## Application for a Non-Material Amendment Following a Grant of Planning Permission

The proposals have been revised to retain the porch on the north-west elevation and install a new air-source heat pump on the north-east elevation (both being marked in red on page 24 of the attached Heritage Statement.

Drawing No	P04E

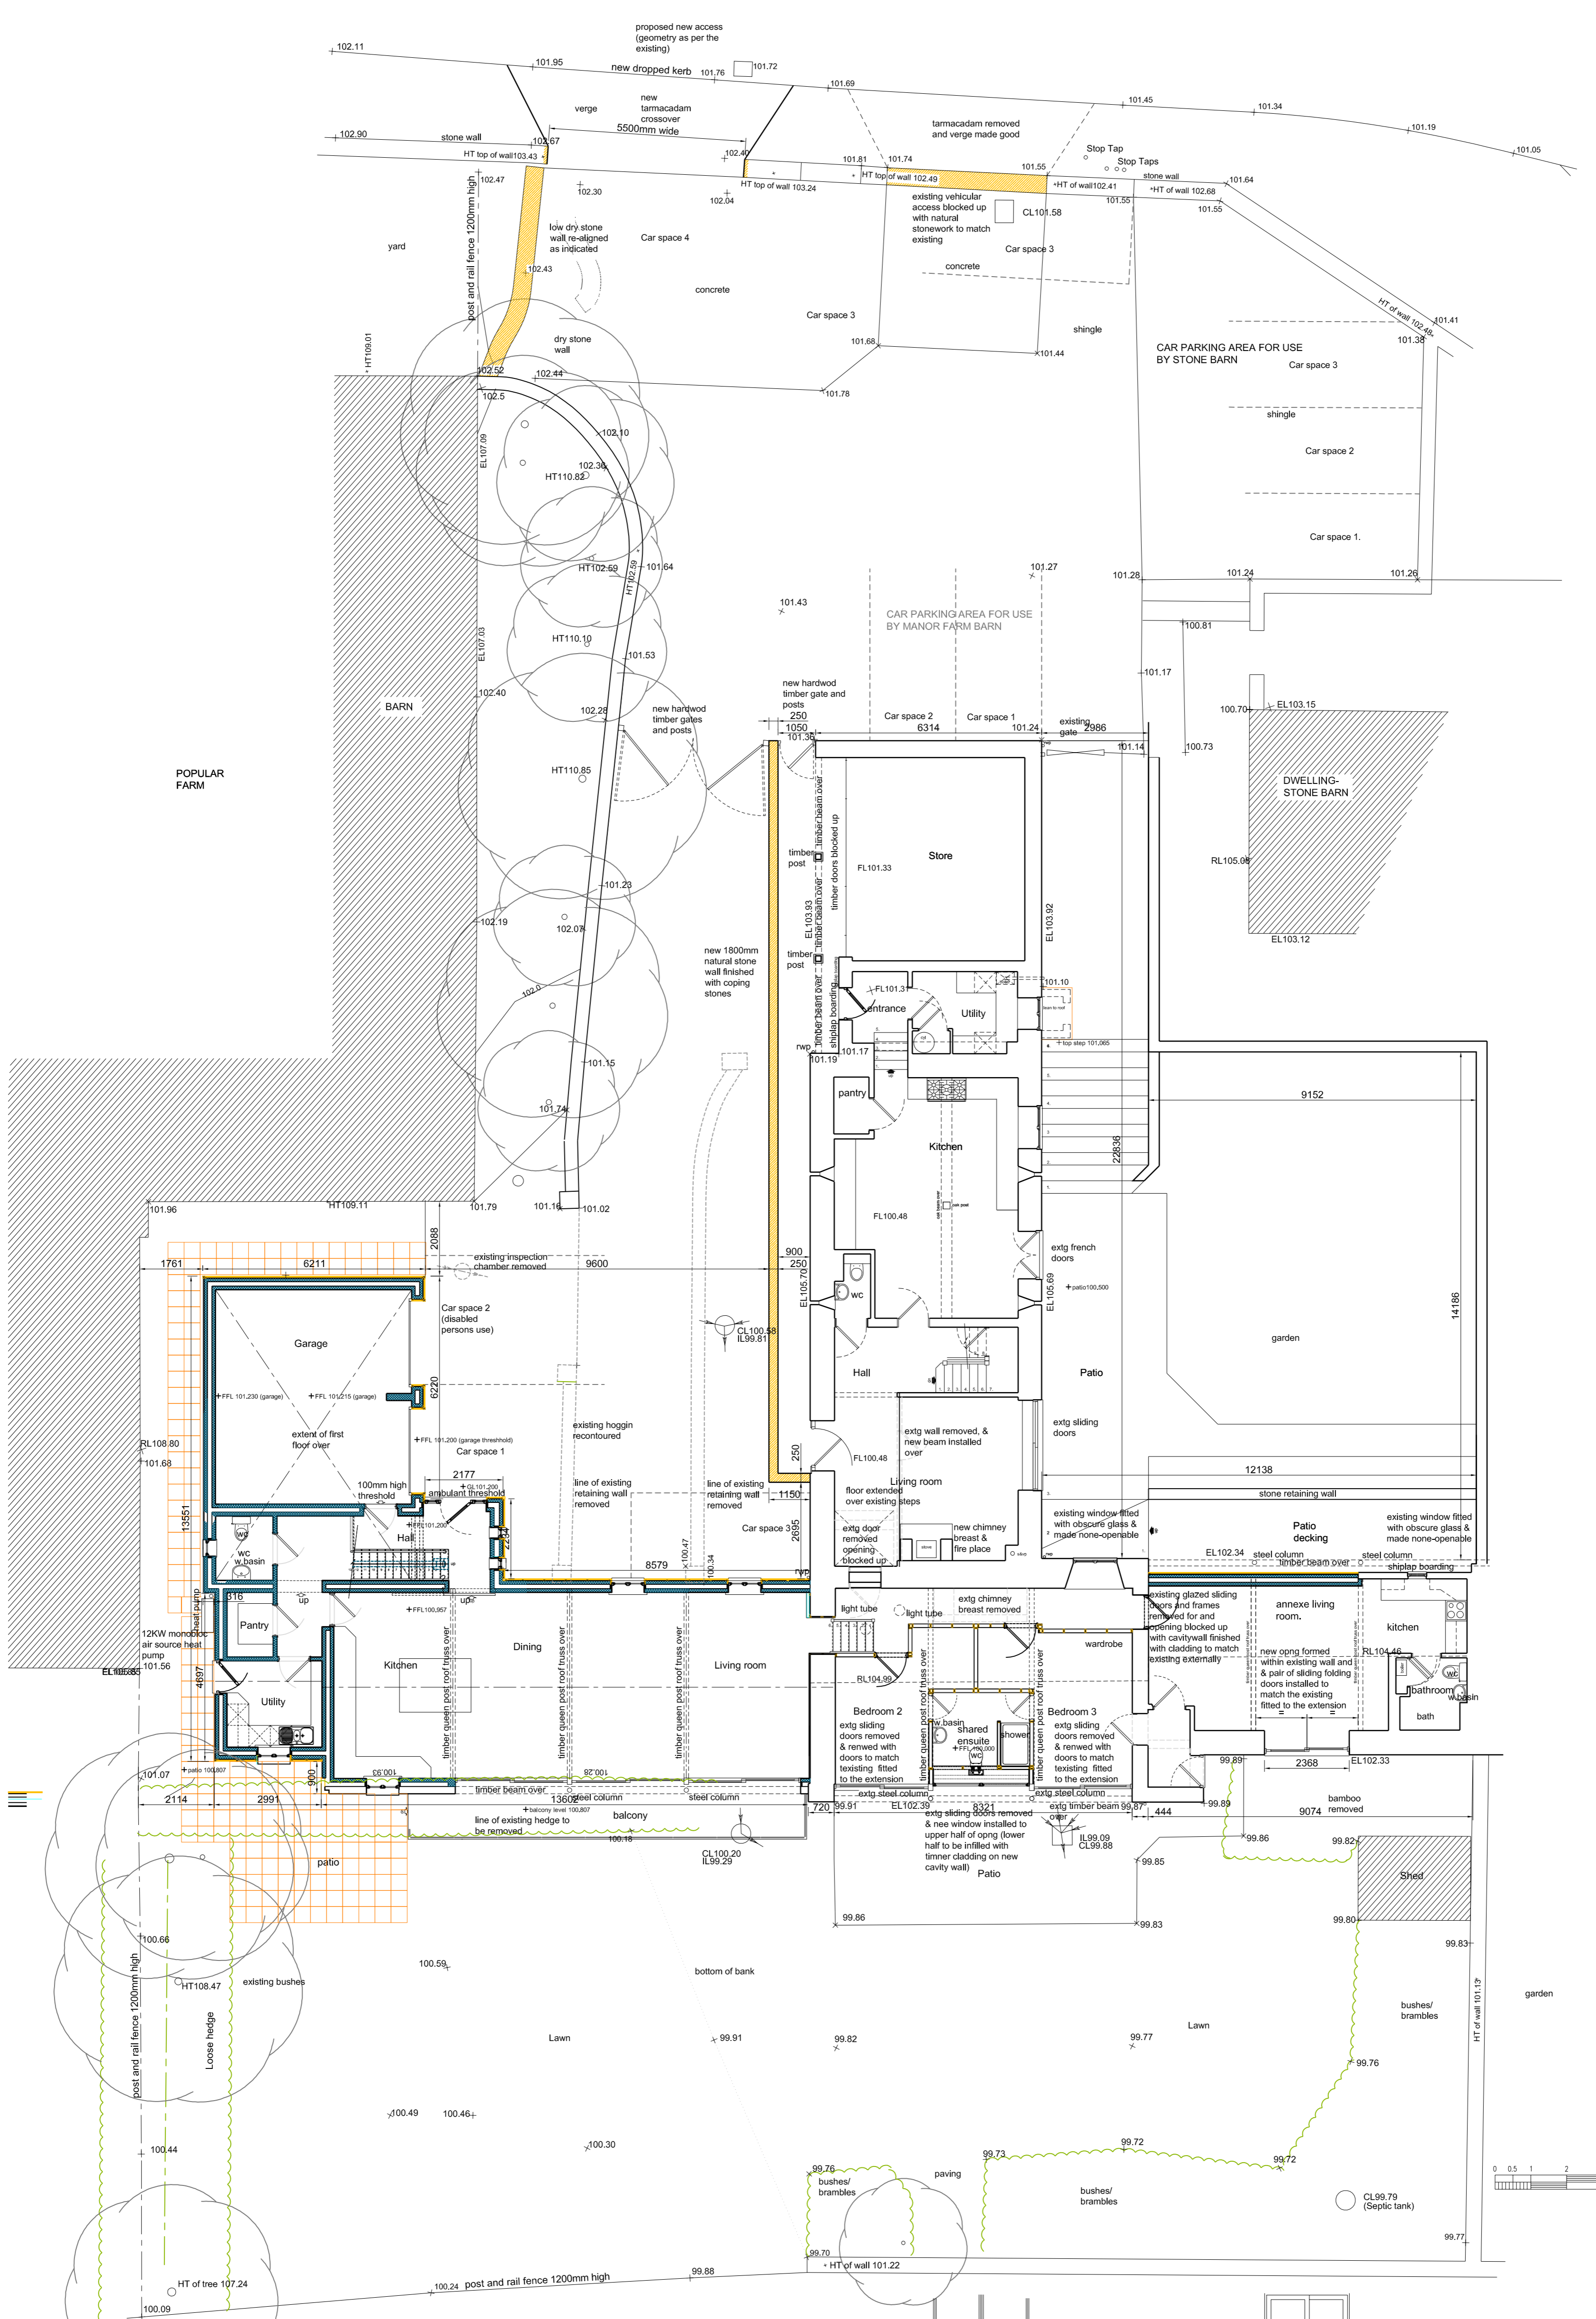
Front porch - The wall materials have been changed from oak framing supporting large glazed panels to walls faced in shiplap matching that in other parts of the new work. the windows are smaller.

Sliding door on the north elevation: The existing sliding door is to be removed and the opening will be partially built up to cill level finished externally with timber cladding to match the existing with a window above to serve a proposed bathroom.

North elevation new sliding door: A new sliding door is to be introduced into the existing external wall facing north.

North elevation replacement sliding doors: The existing sliding doors are to be removed from the north facing wall and replaced with those to match those used on the extended portion of the building on the north facing wall.
